Case Number: ACP 324277-26

Re: Application for Substitute Consent pursuant of Section 177E of the Planning and Development Act 2000 (as amended) consisting of the quarrying of rock that took place between February 1990 and October 2014, along with all associated site works. The application is accompanied by a remedial Environmental Impact Assessment Report (rEIAR) and a remedial Nature Impact Statement (rNIS). Ardcahan (townland), Dunmanway, Co Cork.

An Taisce response 28.7.26

Applicant response 14.8.26

ARDCAHAN QUARRY COMBINED SUBSTITUTE CONSENT REMEDIATION AND S37L REGENERATION PLAN

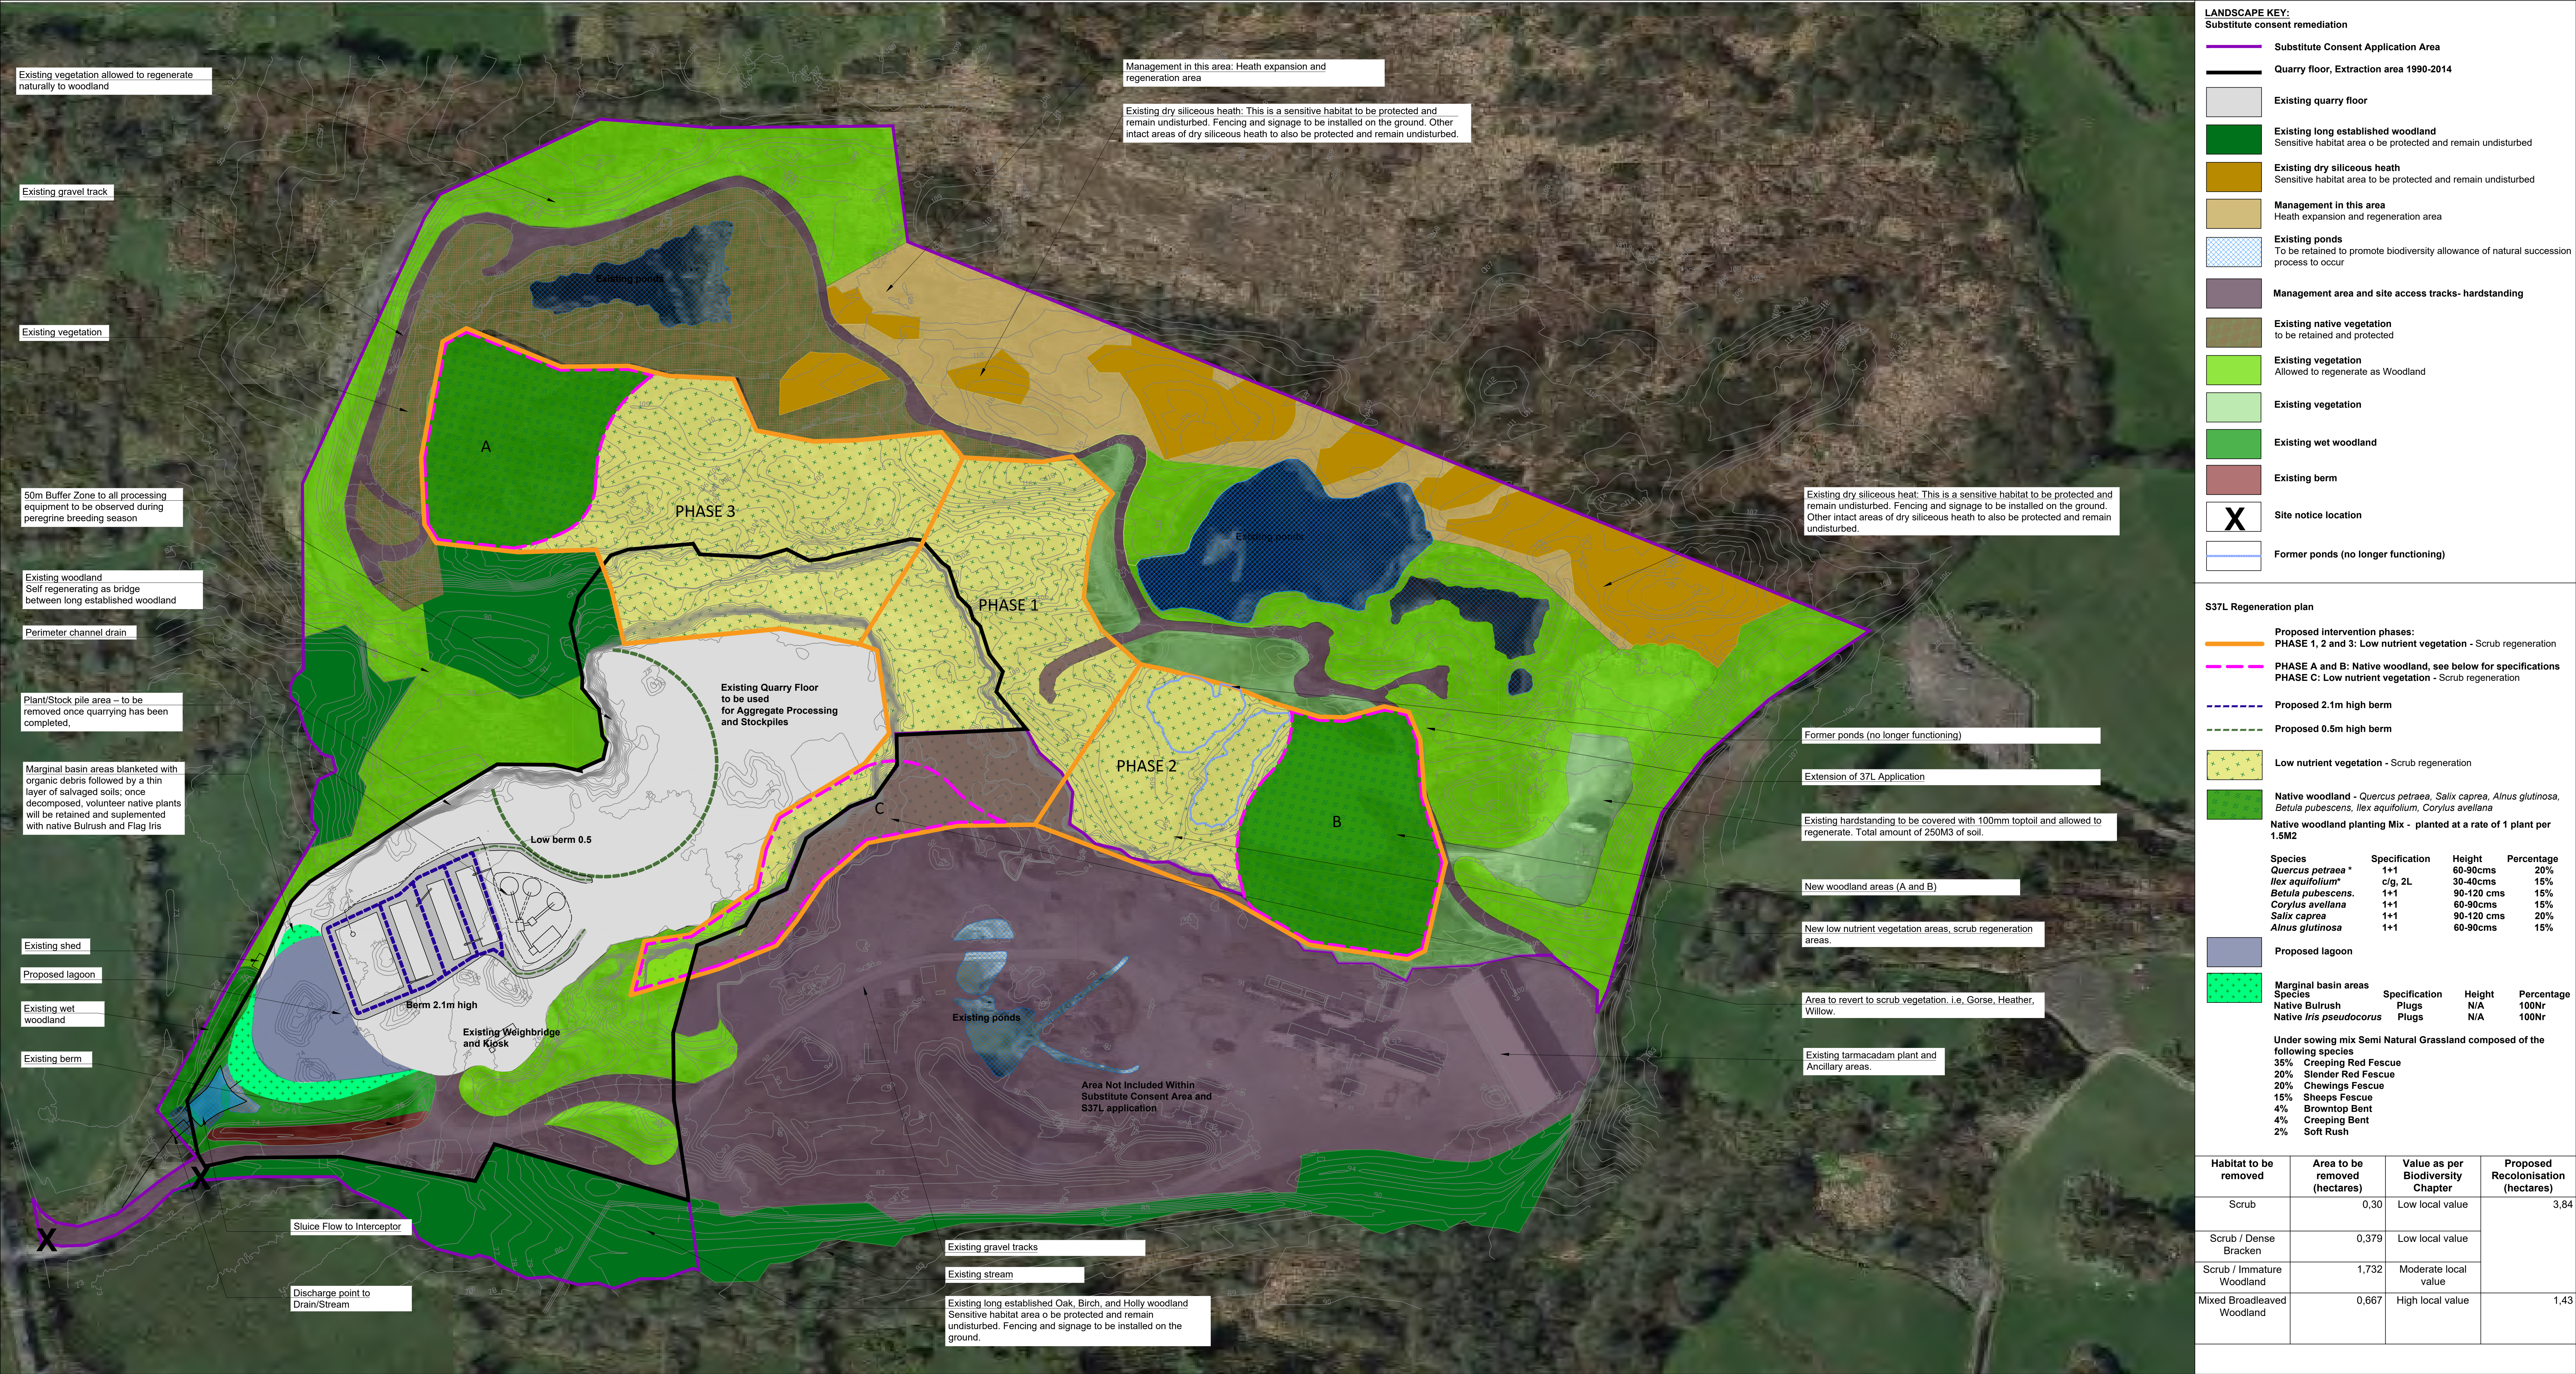
**S37L EIAR Vol 2: Main Statement; 7.4.4.1** There is also talk of a **second quarry access being made in the NW corner of the site**, but there is no sign of it on any map, and will it meet a public road?.

**S37L EIAR Vol 2 Main Statement 11.2.1 Lagoon, Silt Pond, and Washing Facility** the proposed site layout will need to make provision for a clean water lagoon(s) located on the quarry floor. This may involve blasting to form a lake. This whole site would drain into this lagoon(s) and would require a controlled overflow for times of heavy rainfall. this would require a **new discharge point to the Caha Stream** and will require monitoring as well as a possible discharge licence. Note that the Caha River is some 360 meters away to the northwest. There is a group of local farmers who have worked together to prevent any stock related pollution from entering the river, through improved fencing to keep stock out of the river and provide alternative drinking sources. Will all their hard work be in vain.

We formally request that the planning Authority require the applicant to submit comprehensive clear and a fully scaled site map. the current documentation leaves critical structural and logistical details ambiguous, making it impossible to accurately assess the localised environmental and structural impacts, we require the planning authority to enforce clarity on the following points.

**Undocumented Northwest Access:** the applicant states that a new access is required to the Northwest, yet this road is completely missing from the submitted maps. the applicant must clearly mark the exact route of this northwest access. Further-more they must clarify its precise operational boundaries: is this access road located entirely within the site boundary, or does it exit the site **onto** external public/private roads?

**Unmapped Heavy Infrastructure:** the applicant acknowledges that new infrastructure-such as a weighbridge and associated facilities-is "likely needed," yet these major structures have not been positioned or marked on the site plan. All proposed infrastructure must be definitely located and mapped.

**HGV Traffic Routes:** Heavy Goods Vehicles generate significant mud, dust, and dirt. Because the applicant has failed to map the second northwest access and weighbridge, the exact transit routes of these lorries remain unknown. We require a clear mapping of all HGV internal and external transit routes to evaluate the true extent of dust and mud pollution.

While the applicant proposes mitigation measures and re-seeding to combat the environmental degradation, the specific areas designated for these remediation works are completely unclear. The exact zones for reseeded and environmental mitigation must be distinctly marked out on a unified site map so their proximity to sensitive areas (and their overall efficacy) can be properly evaluated.

Aerial Image 2000

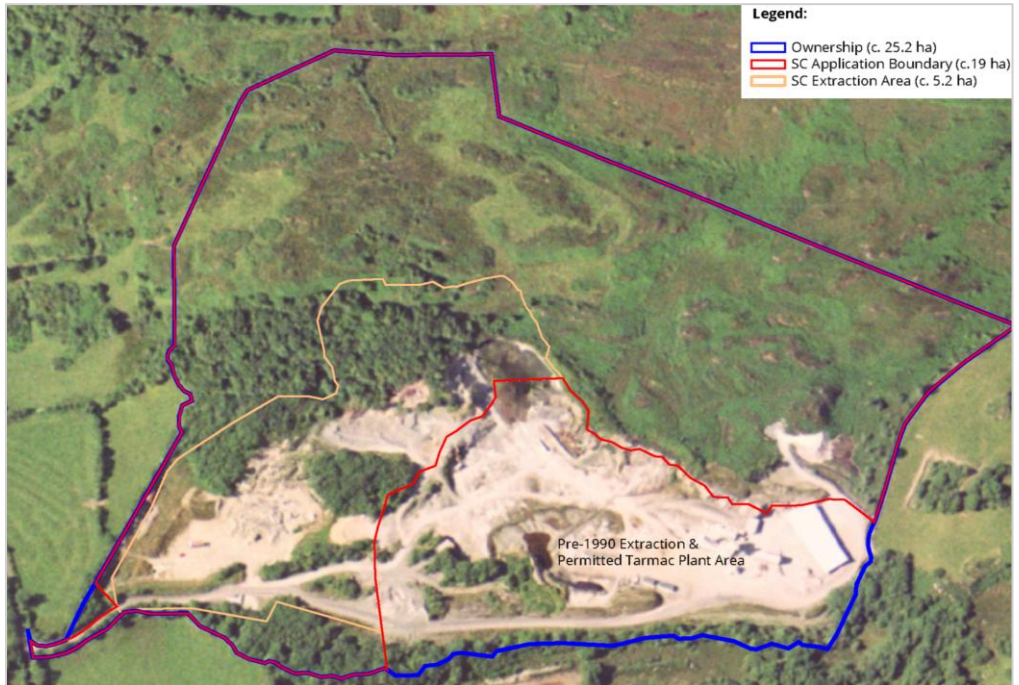
The second photograph on page 41, taken in 2000, shows a new pale area to the west of the old 'top' quarry and this is the part that is under active excavation, this was previously woods and fields. This new quarry is the area which the Applicant has been excavating to a depth of 74 meters OD. This area is adjacent to the 'top' quarry but has separately accessed from the southwest. This 'lower' level was not being quarried prior to 1990, hardly scratched by 1995, and therefore it is disingenuous to suggest that just because there was a quarry somewhere nearby, then it must be legitimate; this new area is a distinct, unauthorised phase of site clearance and extraction which occurred well after the statutory baseline dates, directly undermining the applicant's claim of long standing historical immunity.

Aerial Image 2005

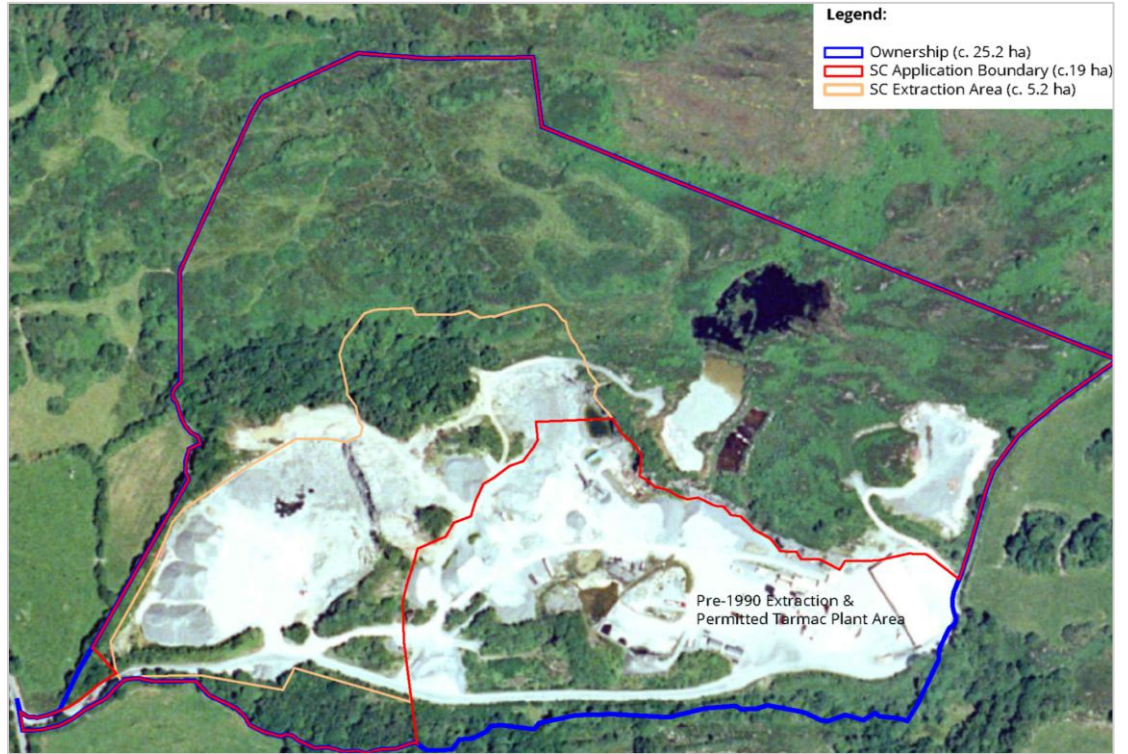
The photograph on page 42, taken in 2005, shows the newer 'lower' quarry now fully developed, with rounded piles of crushed stone at the western side and a prominent line running north-south marking the quarry face which will be moving eastwards. Please also note white areas to the east of

the site which are unconsolidated spoil without any vegetative cover and subject to rainwater runoff adjacent to the boundary stream. This ariel photograph also highlights just how much white there is, they are all areas of the 'quarry environment' type, characterised by hard surfaces, coated with mud or dust, and highly mobile on windy days or rainy days.
